Application No: FG/32/25/HH
Site Address: 1 Greenways Crescent Ferring BN12 5EF
Description of works: Erection of 1.8m high close boarded timber fencing along the eastern boundary.

Thank you for your internet representation made on 4th April 2025 which has been recorded as an objection with the comments as follows:

DRAWING TITLE
Existing Site Plan

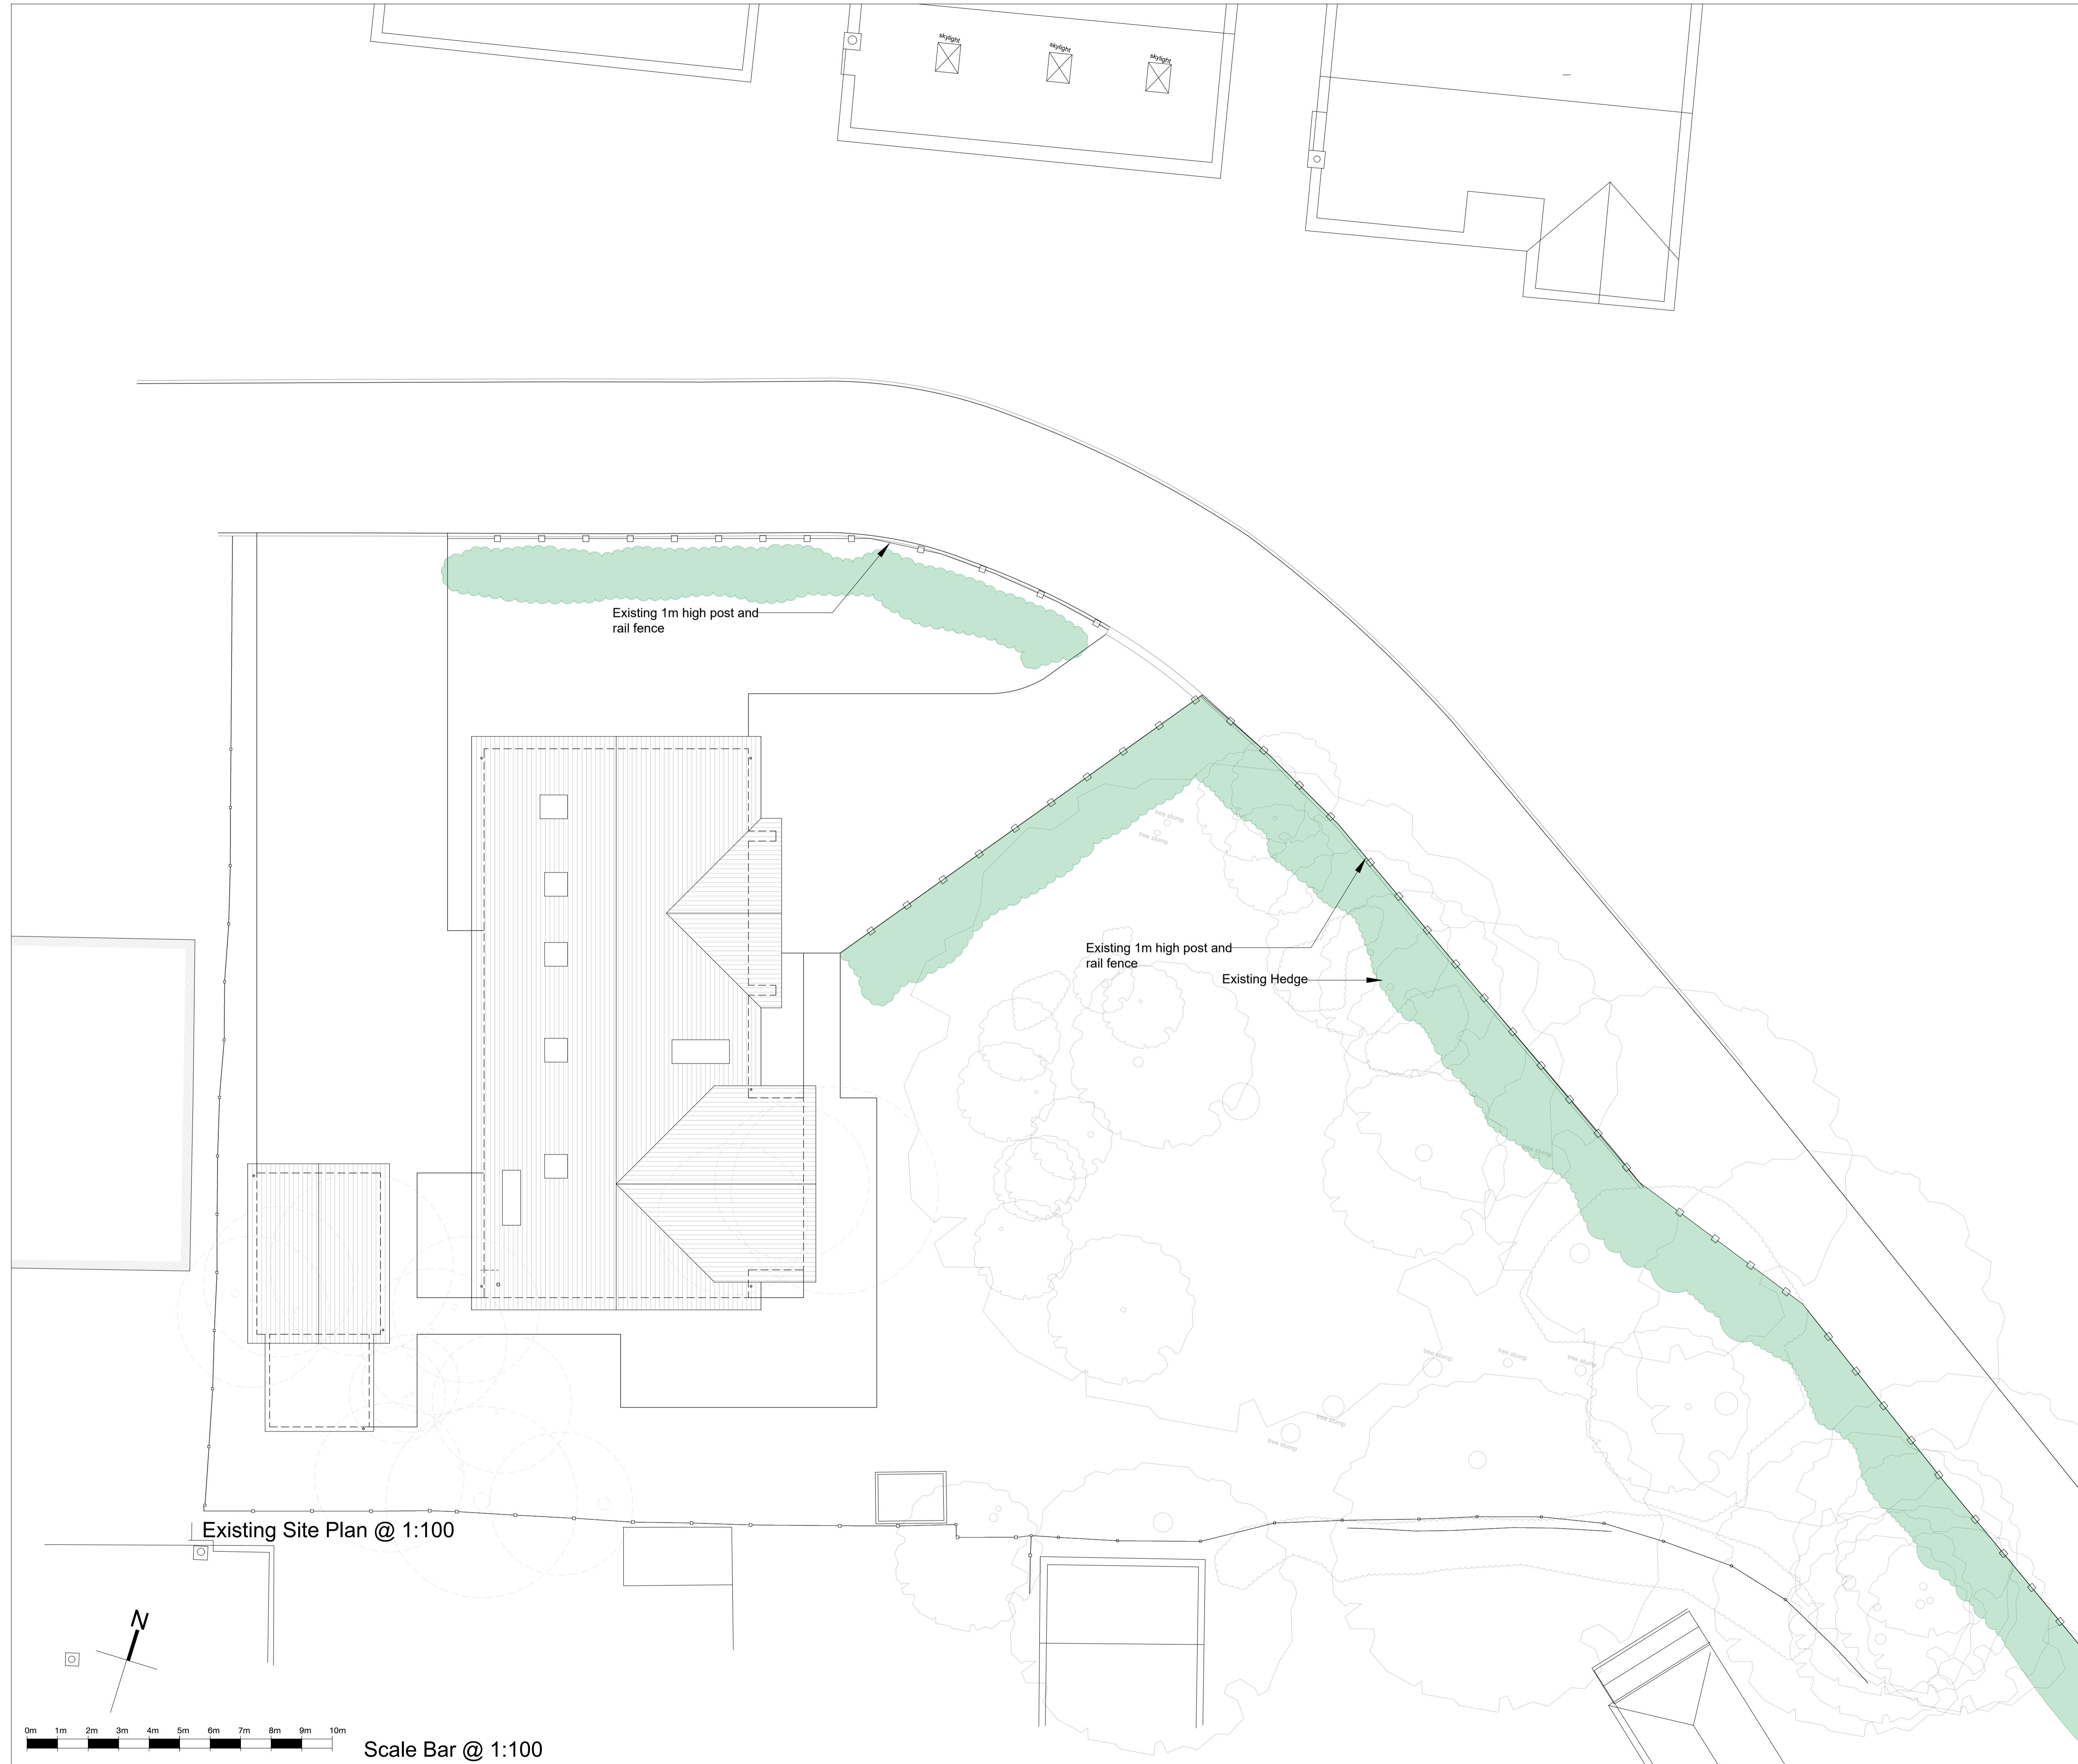
In the application there is a signed declaration saying that the land to which the application relates to is wholly owned by the owners of no1. This land is defined by the red line. The drawings show the fence line comes out to the kerb beyond the existing fence and bushes even takes in the muddy bit where there is no made road. This would be very imposing on the road and houses opposite this current proposal.
